Subject: FW: Response To Application Number BR/282/19 at The Beach Hotel, former Mud Club & 2-4 Waterloo Square Bognor Regis PO21 1SU

Please WSCC Highways response to the amended scheme. They are requesting further information:

Drawing No.	Rev.
2020-6153-001	A

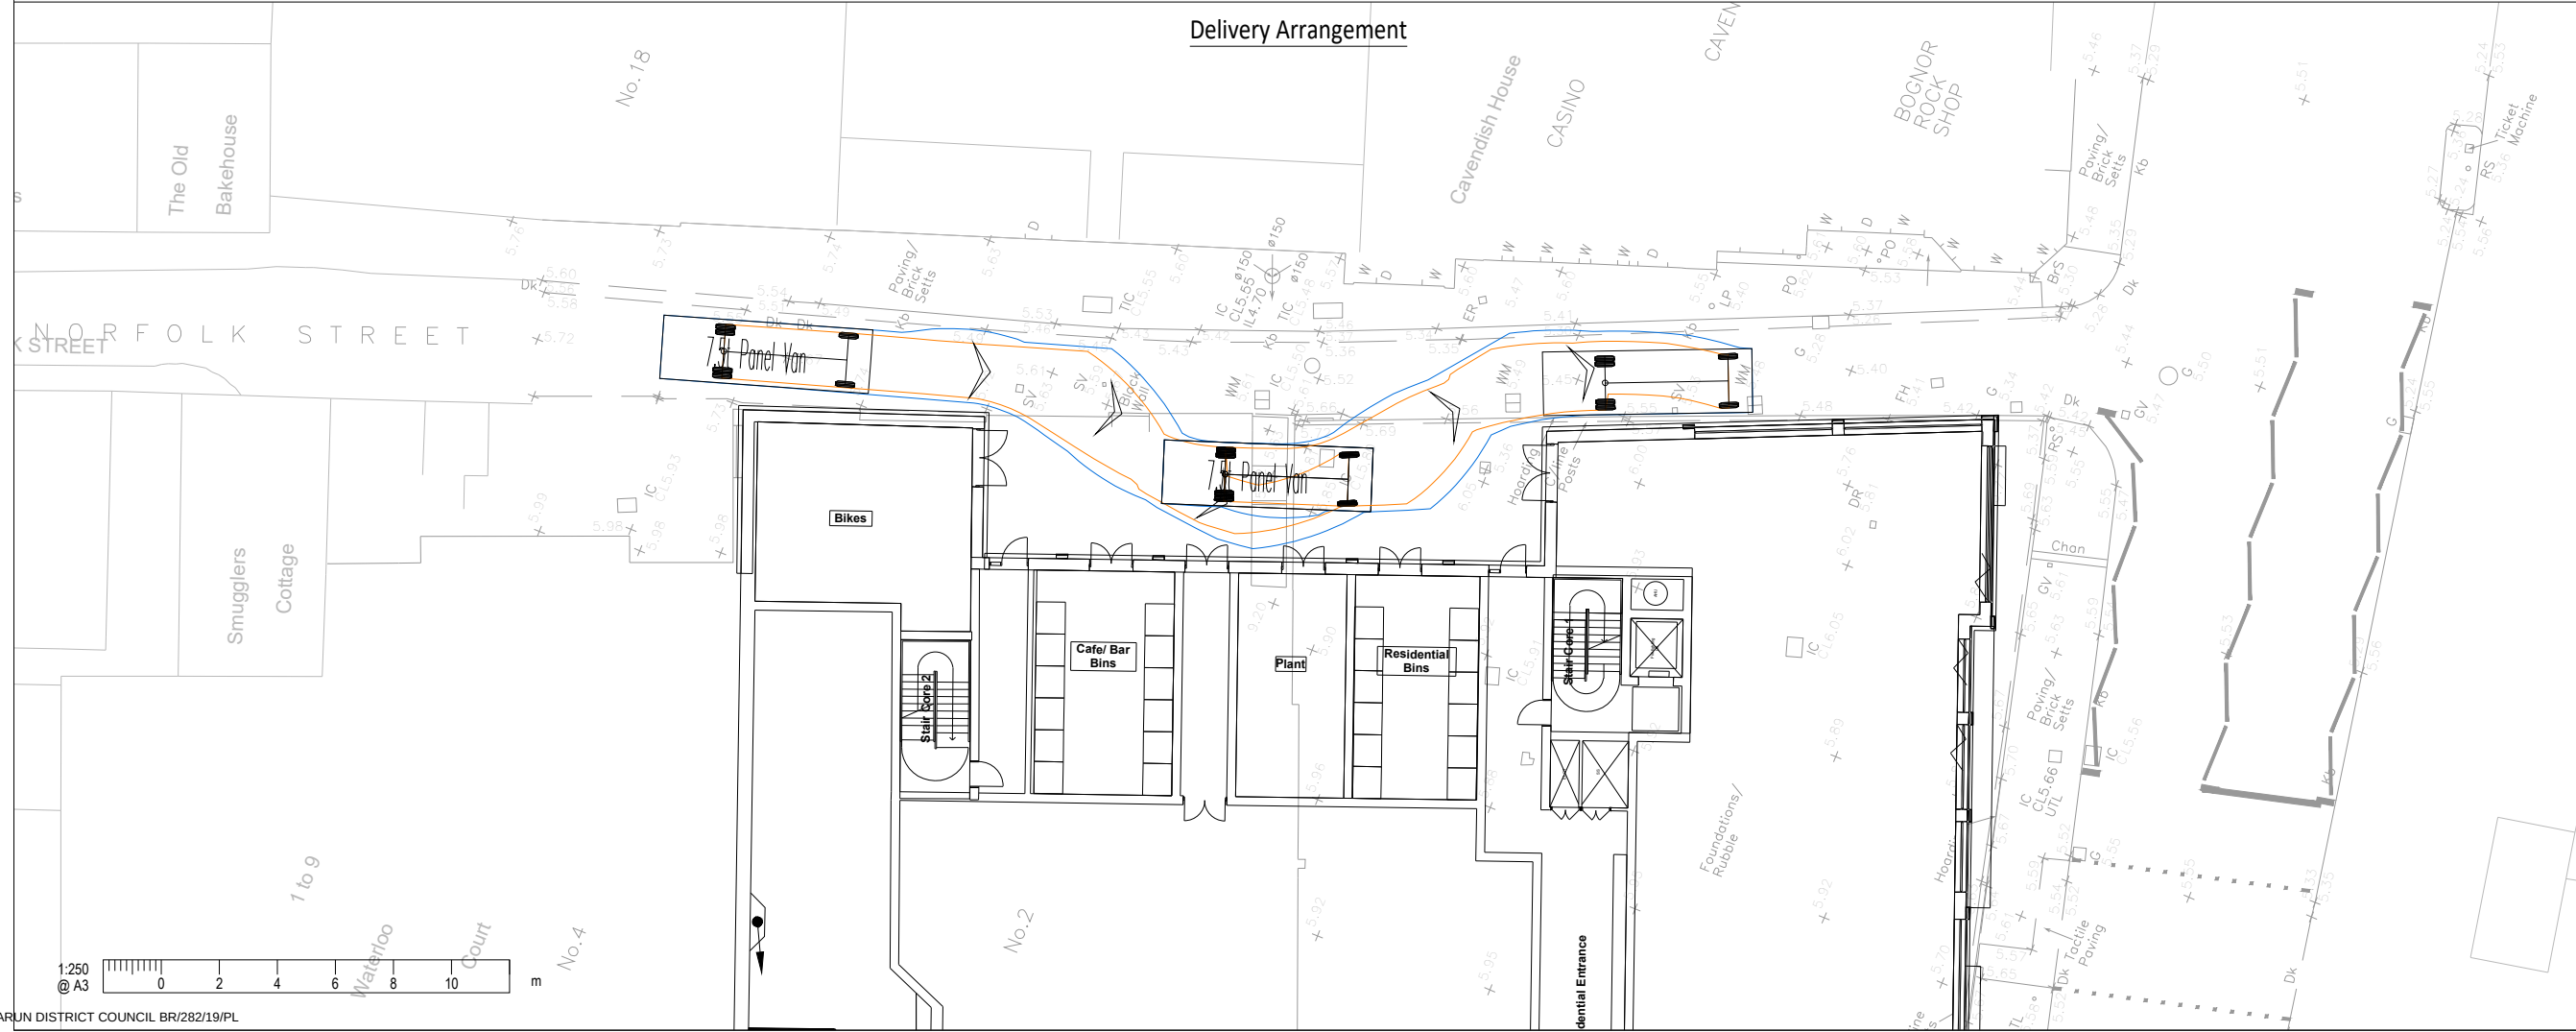
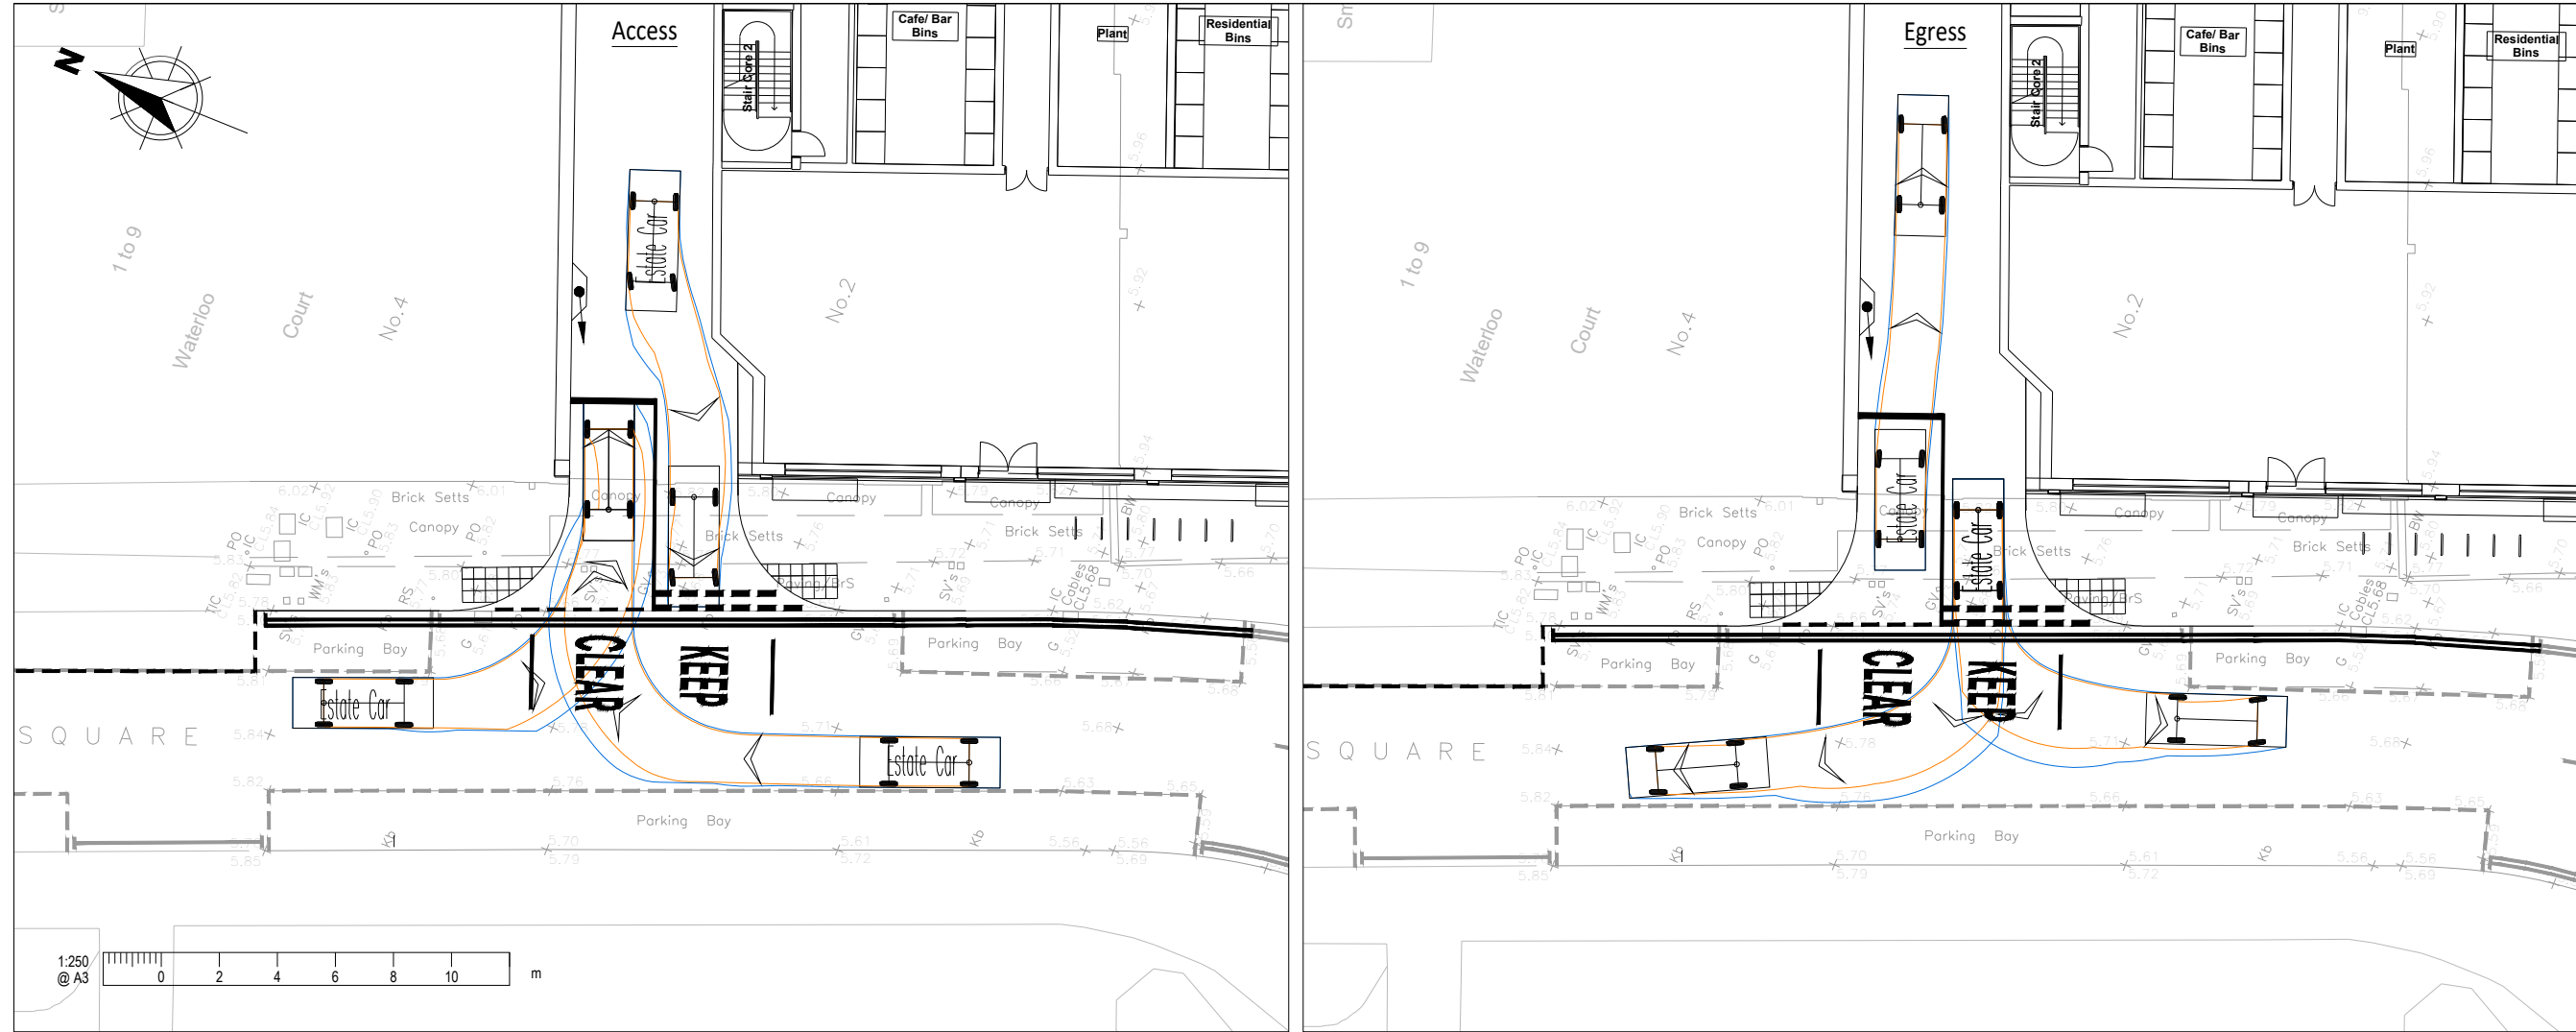
- Updated desktop based (no SV required due to the lockdown) RSA to assess alterations to access arrangements including access to parking and loading bay arrangements.
- Swept path tracking diagrams to fully demonstrate workability of proposed parking spaces and loading bay including wider access from High Street/West Street for anticipated vehicles (refuse/ deliveries).
- Trip generation – amended assessment of the anticipated vehicular trip generation from both residential and commercial element.
